Our ref: WA/2014/118529/01-L01
Your ref: 14/01384/OUT
Date: 6 October 2014

Development comprising redevelopment to provide up to 2600 residential dwellings (class c3), commercial floorspace (class a1 - a5, b1 and b2), social and community facilities (class d1), land to accommodate one energy centre, land to accommodate one new primary school (up to 2fe) (class d1) and land to accommodate the extension of the primary school permitted pursuant to application (reference 10/01780/hybrid). Such development to include provision of strategic landscape, provision of new vehicular, cycle and pedestrian access routes, infrastructure, ancillary engineering and other operations.

Bicester Eco Town Exemplar Site, Banbury Road, B4100, Caversfield.

Title: **Modelled Flood Extents Application 1 Site**

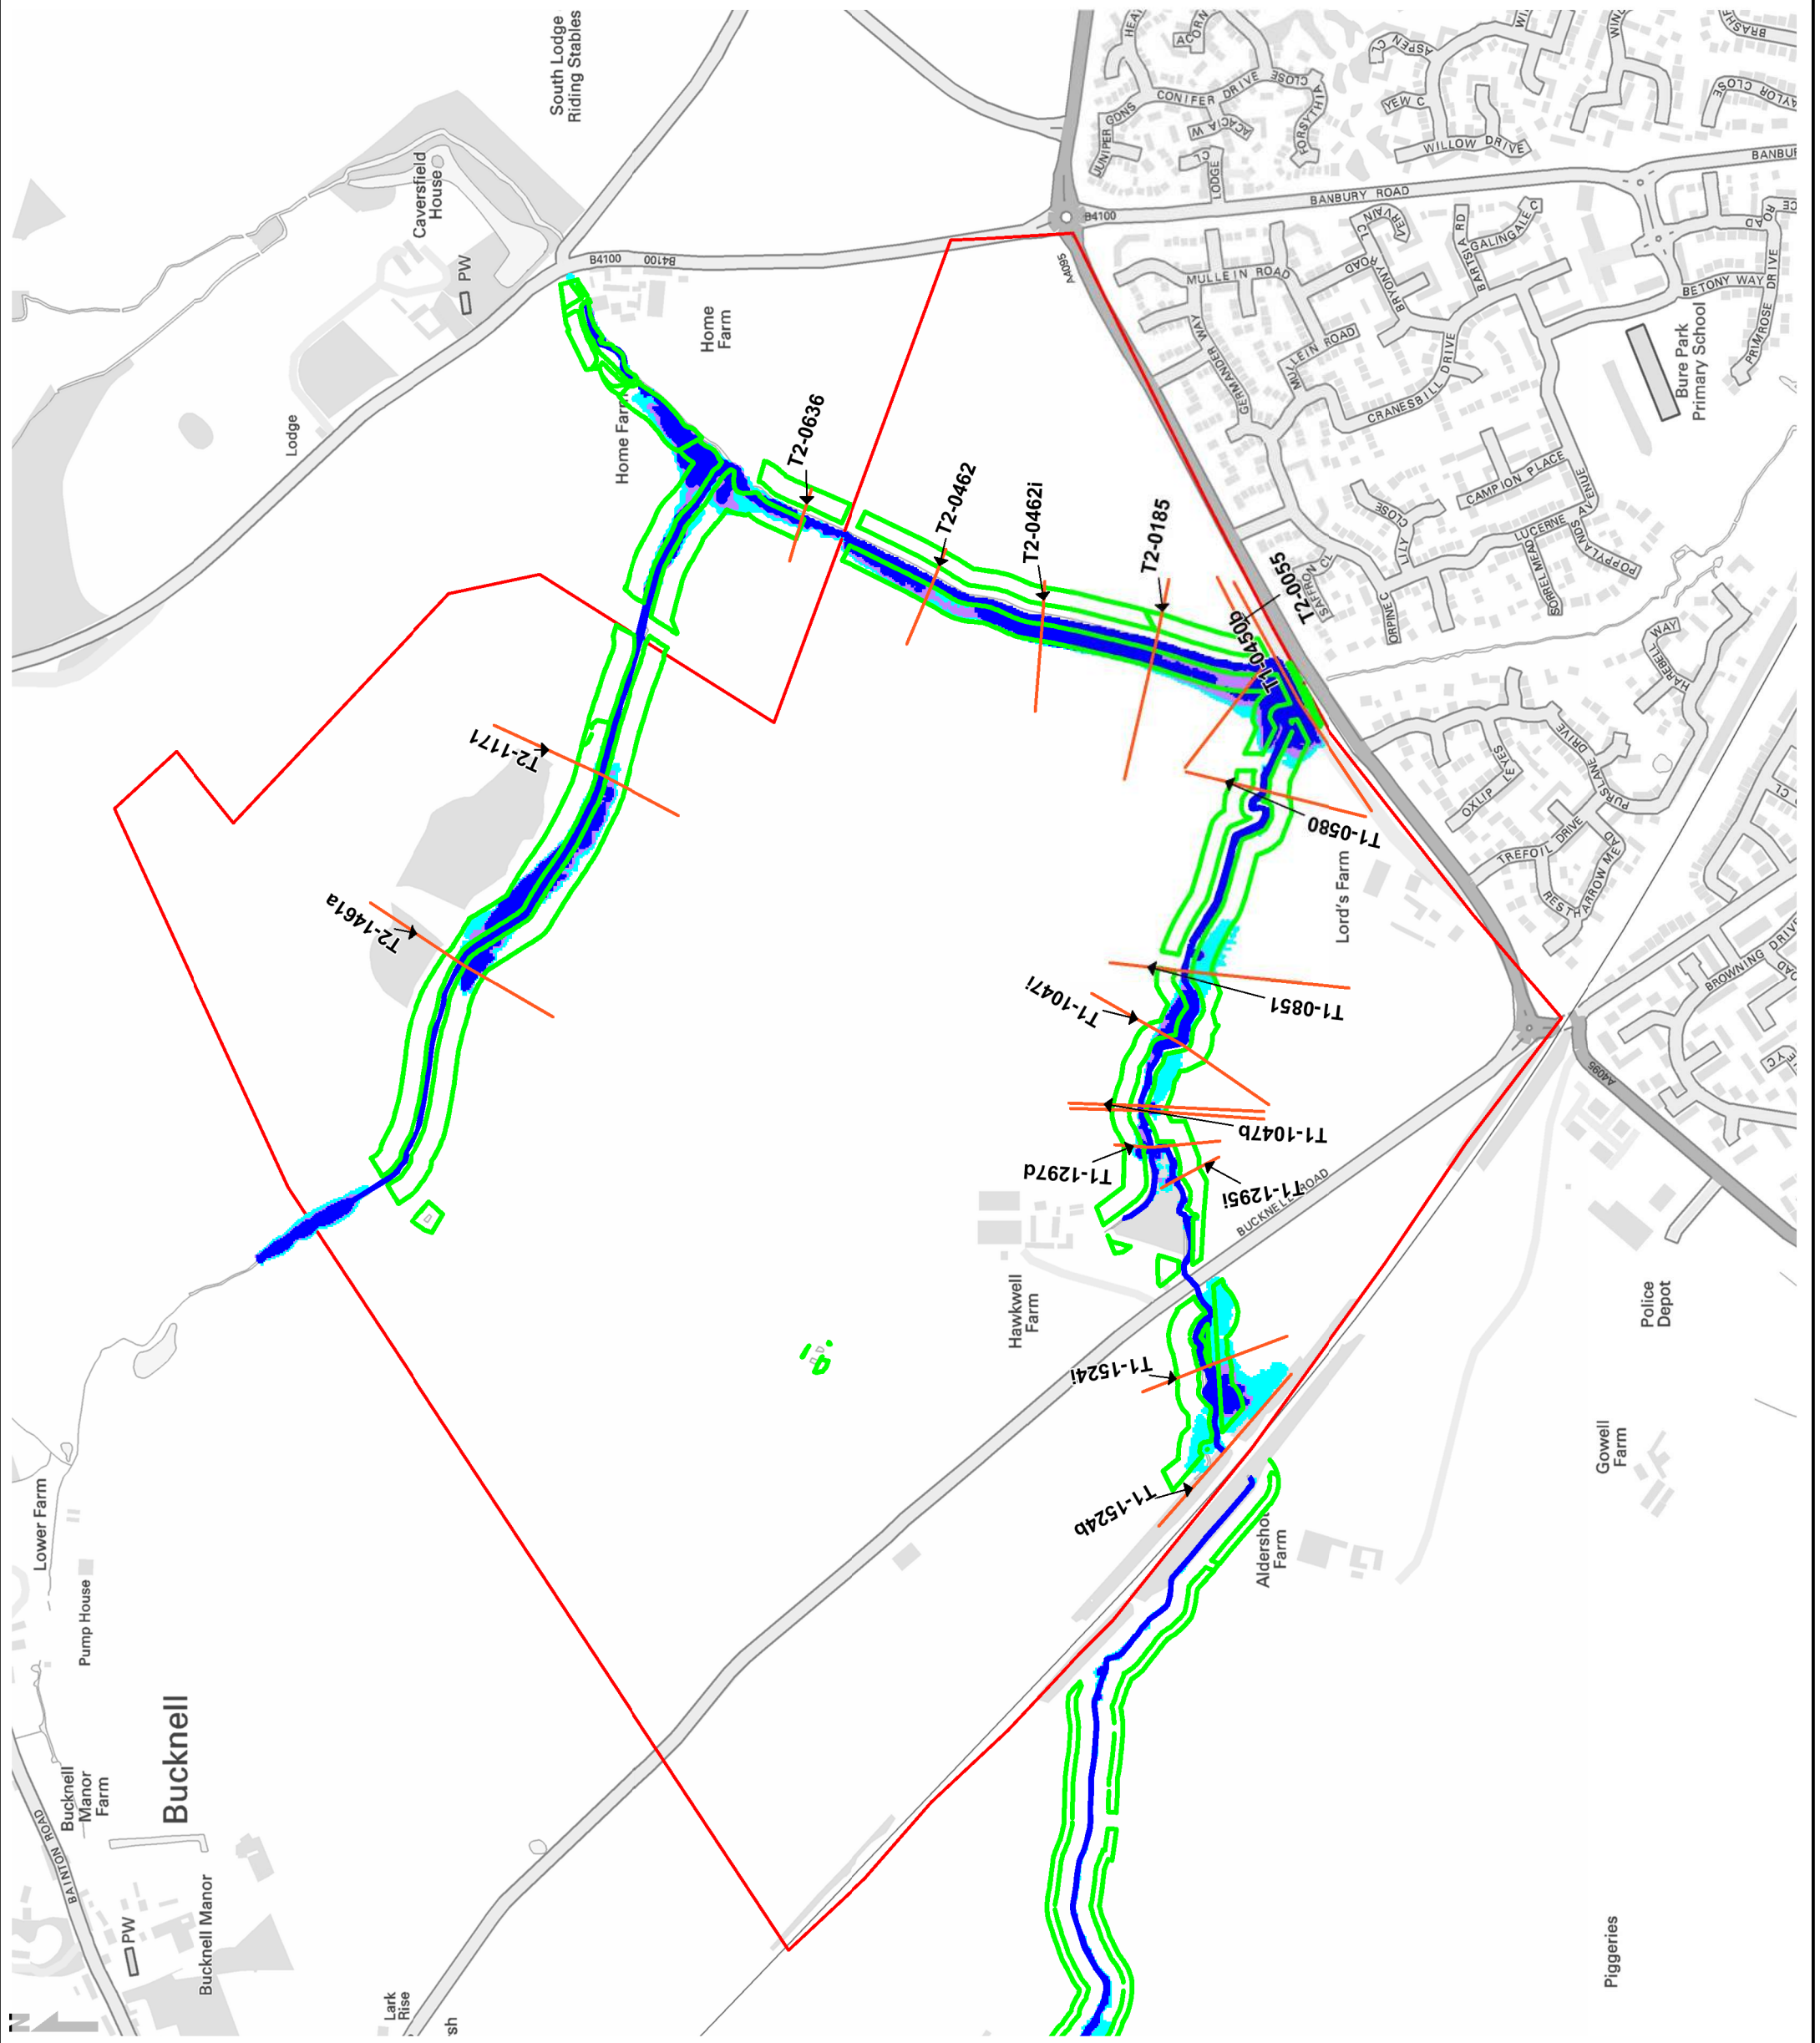
Condition: There shall be no built development (buildings) within Flood Zone 2 & 3 as defined in Appendix 6 plans – modelled flood extents for the 100 year and 1000 year events (Flood Zone 2 & 3) of the Outline Application NW Bicester Planning Application 1 Flood Risk Assessment and Surface Water Drainage Strategy –Hyder, ref 5040-UA005241-BM-01, Aug 2014 (Appendix 7a of the Outline Application North West Bicester Planning Application 1 Environmental Statement: Volume 1: Main Text, Hyder (ref 5050-UA005241-UE31R- 01, Aug 2014)
